**CITY OF ALBUQUERQUE
PLANNING DEPARTMENT
DEVELOPMENT SERVICE / HYDROLOGY SECTION**

DATE: 6-7-13
CONFERENCE RECAP

DRAINAGE FILE: G15 0648

SUBJECT: Construct Modular Bldgs

C102

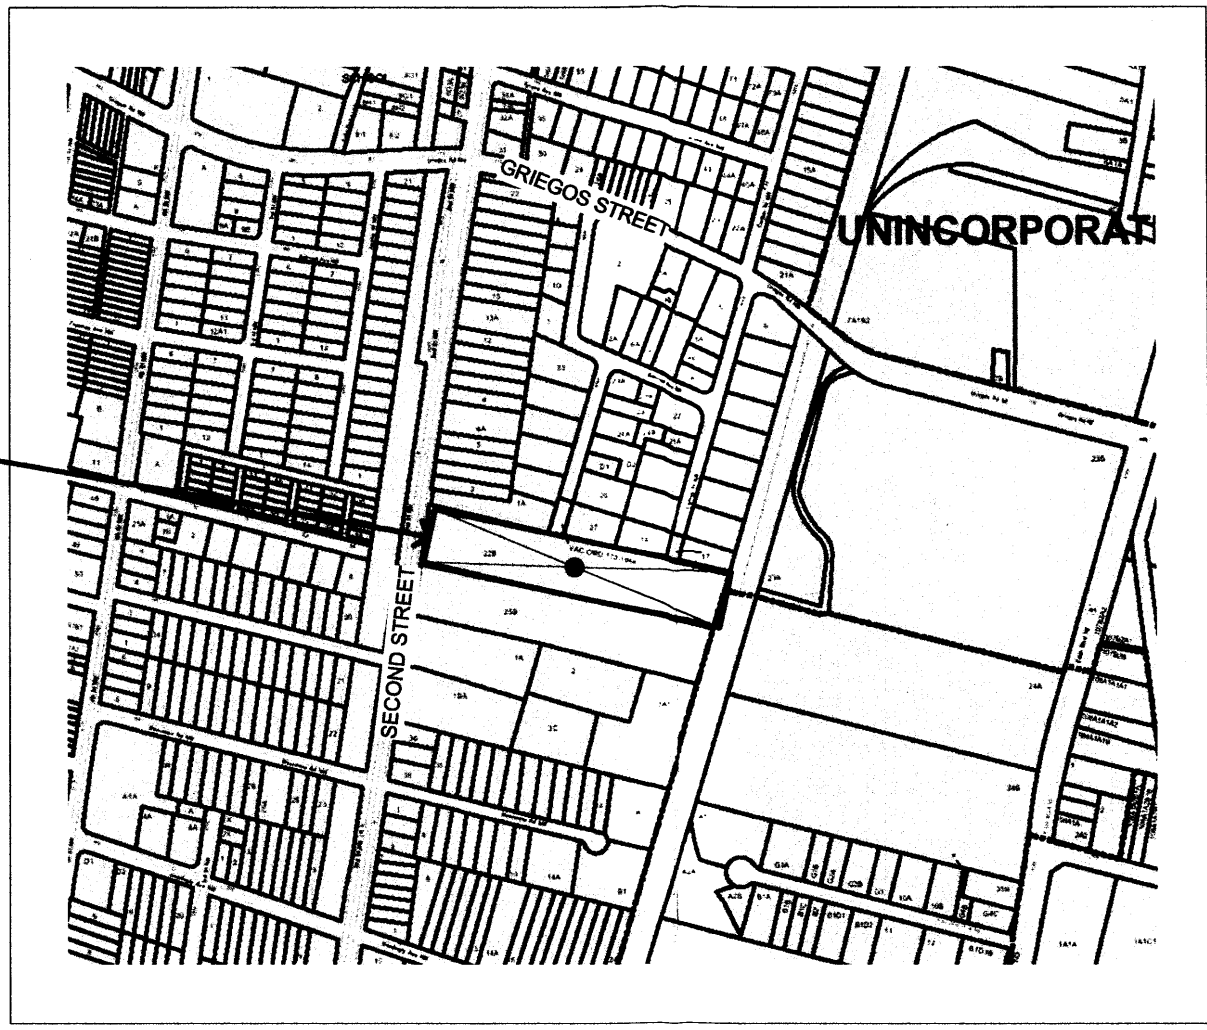
Modular Building to drain to onsite inlet south of the proposed bldg or to inlet in private Street south of proposed Bldg.

show flow arrows on the site plan.
